Project Special Provisions
(Version 06.6)
Signals and Intelligent Transportation Systems

1. 2006 STANDARD SPECIFICATIONS FOR ROADS & STRUCTURES

The 2006 Standard Specifications are revised as follows:

ENGLISH DETAIL DRAWING FOR  
**INDUCTIVE DETECTION LOOPS**

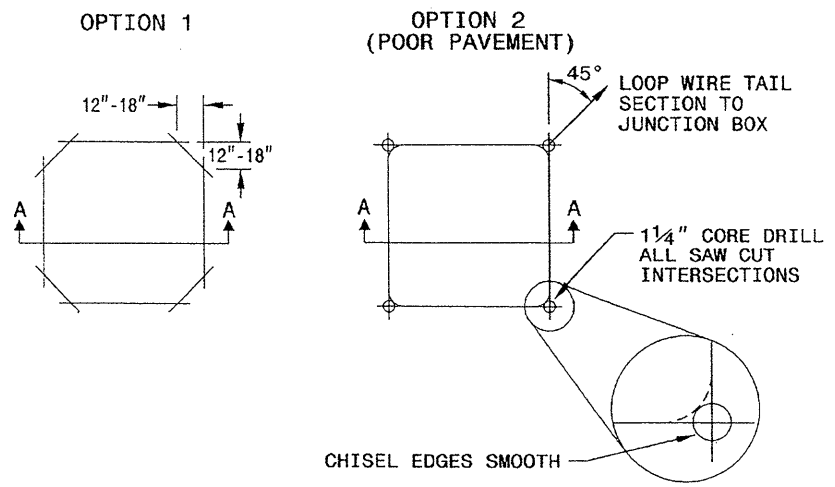
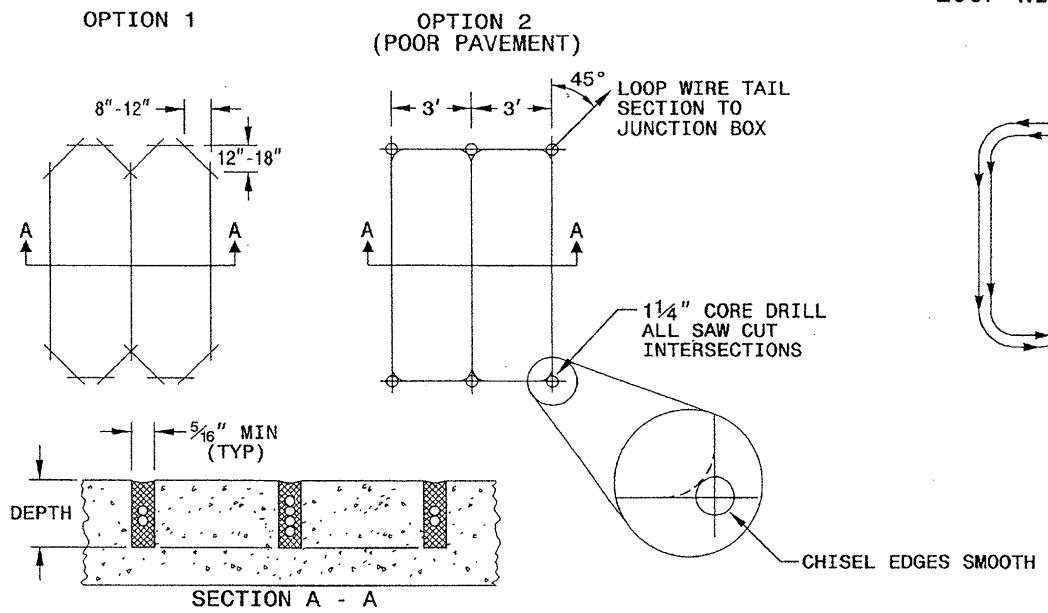
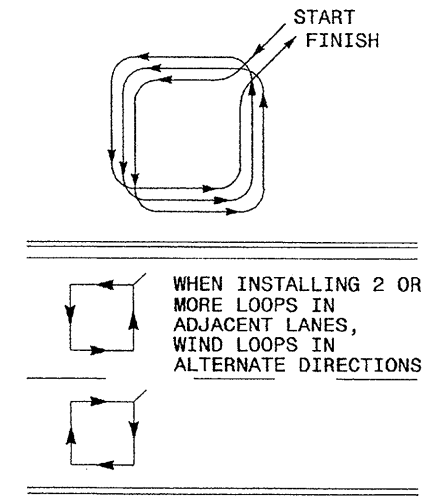
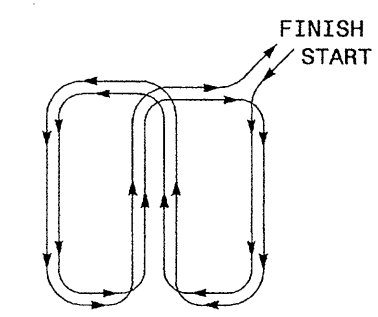
1.4. Inductive Detection Loops – Construction Methods (1725-3)

Page 17-20, Subarticle 1725-3, In the first paragraph, revise the first sentence to:

“Between where loop conductor pairs leave saw cut in pavement and junction boxes, twist loop conductor pairs a minimum of 5 turns per foot.”
